DOC17/615496-1
MP10-0183 MOD1

OEH Review of Environmental Assessment – Teralba Quarry Extension Project Modification 1 (MP10-0183 MOD1)

OEH has undertaken a review of the 'Environmental Assessment of Modification 1 for Project Approval 10_0183 for the Teralba Quarry' prepared for Metromix Pty Ltd by R.W. Corkery & Co. Pty. Limited (dated December 2017). OEH's recommendations are provided in **Attachment A** and detailed comments are provided in **Attachment B**.

Figure 7: Biodiversity Offset

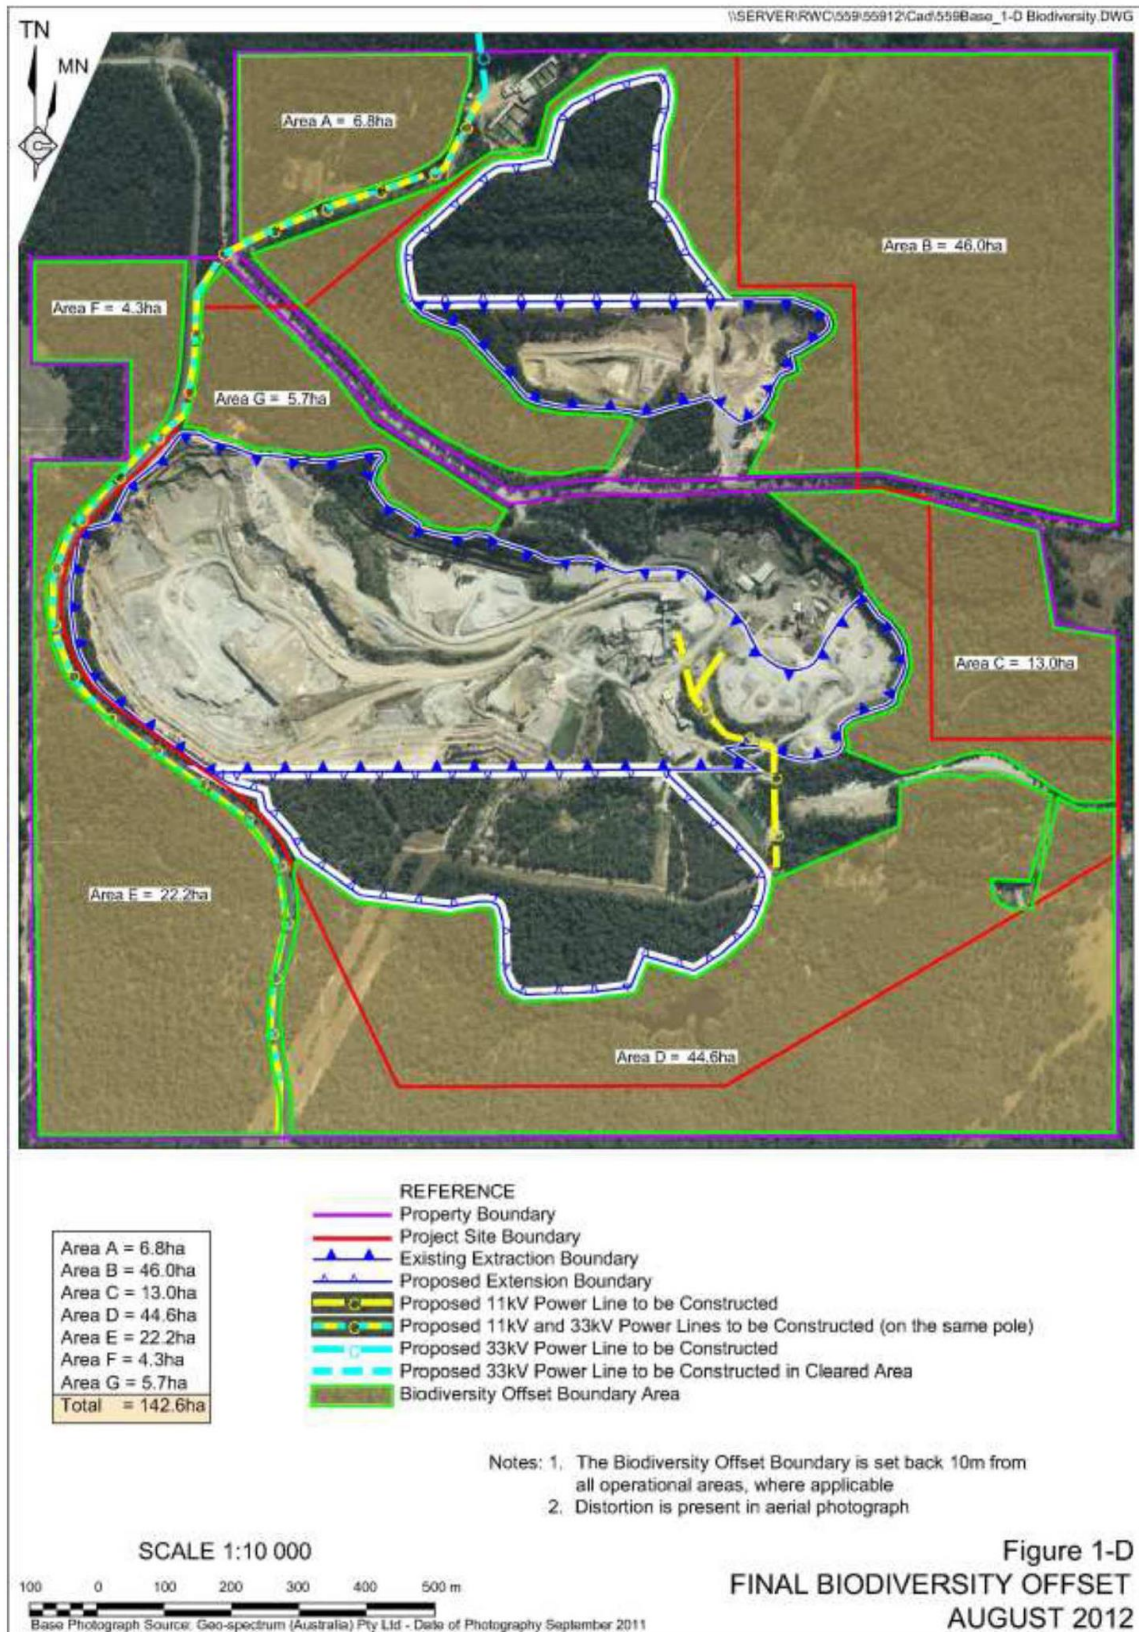
As the proponent is proposing to use the options available under the Biodiversity Offset Scheme of the BC Act to satisfy their offset obligation, a land-based offset may not be used to meet that

obligation. Condition 53 should therefore refer to the timeframe for satisfying the offset obligation of the proposed modification project, rather than solely referring to a timeframe to establish a conservation mechanism for a land based offset.

By 31 December 2018, the applicant must have retired all the ecosystem and species credits listed in table 1 (see condition 52) in accordance with the Biodiversity Offset Scheme of the Biodiversity Conservation Act 2016.

REHABILITATION STRATEGY

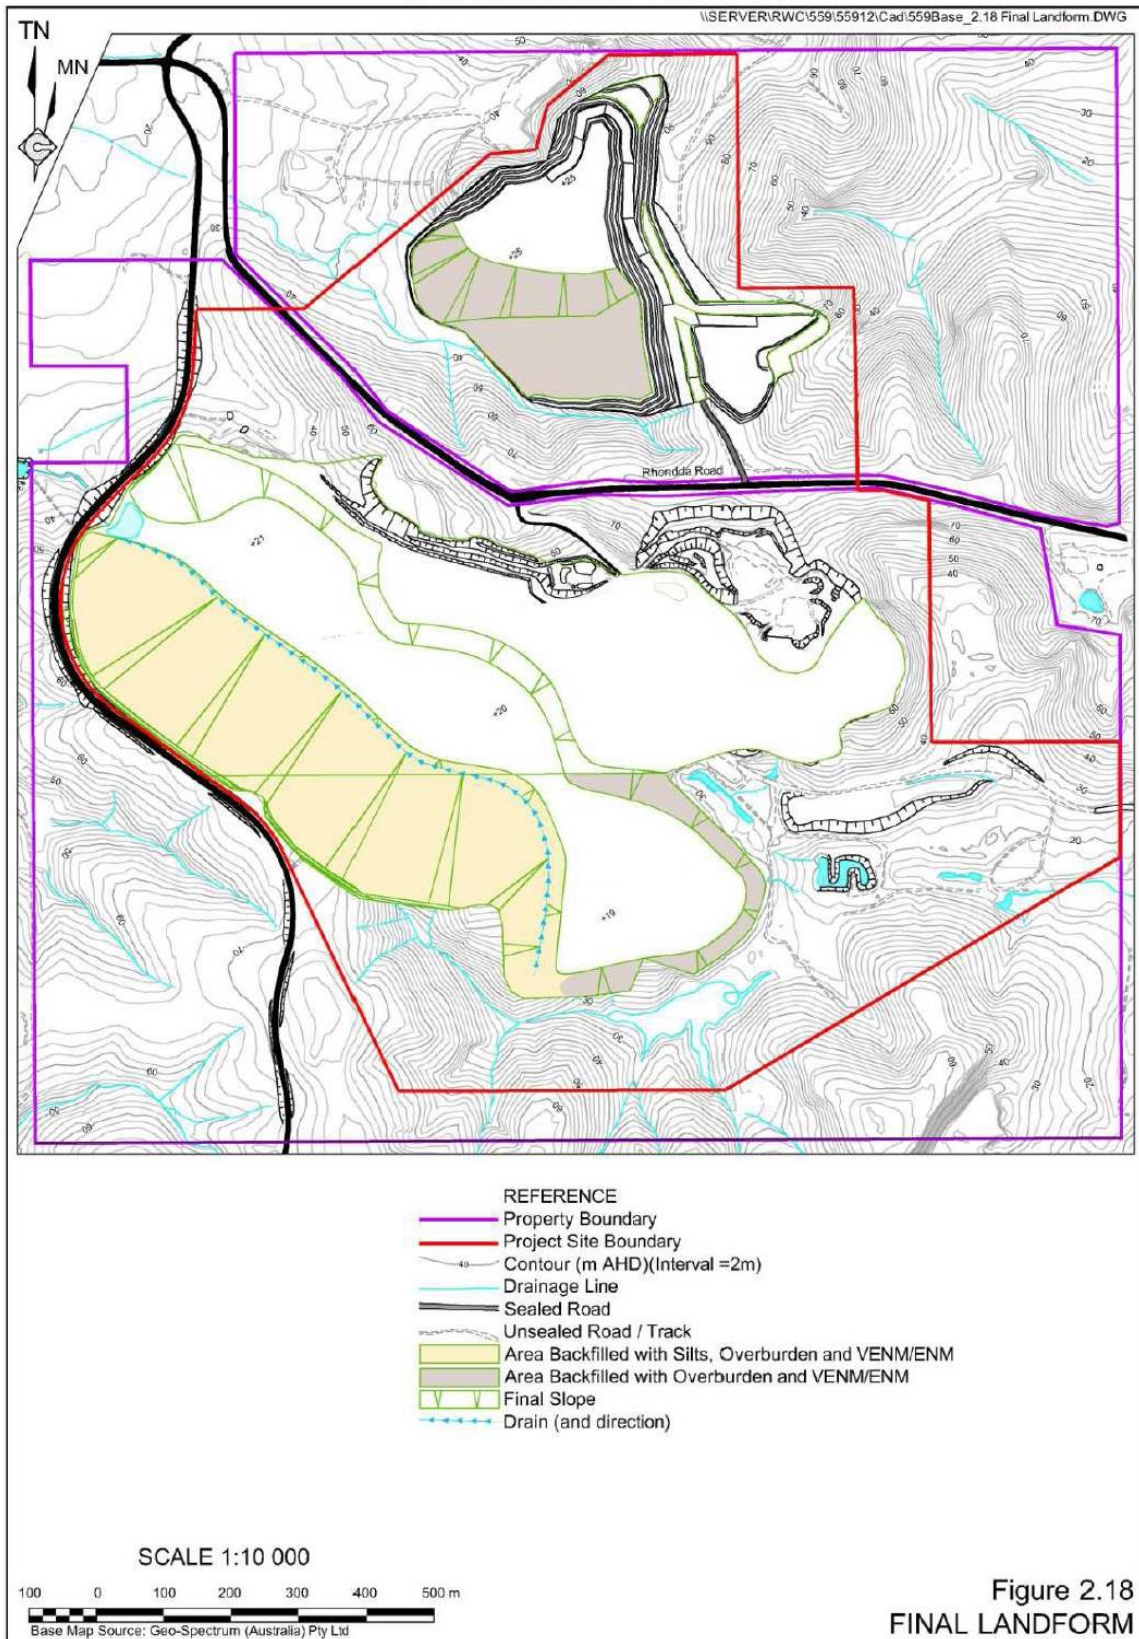
The proponent has proposed using rehabilitation as an option to meet or partially meet their offset obligation for the proposed modification. Only mine site rehabilitation can be used to generate credits to satisfy an offset obligation under the Biodiversity Offset Scheme of the BC Act. Quarries are not defined as a mine under the mining legislation and as such this option is not available.

Rehabilitation cannot be used to retire biodiversity credits for the proposed quarry modification project and all references to using rehabilitation as part of the offset package should be removed.
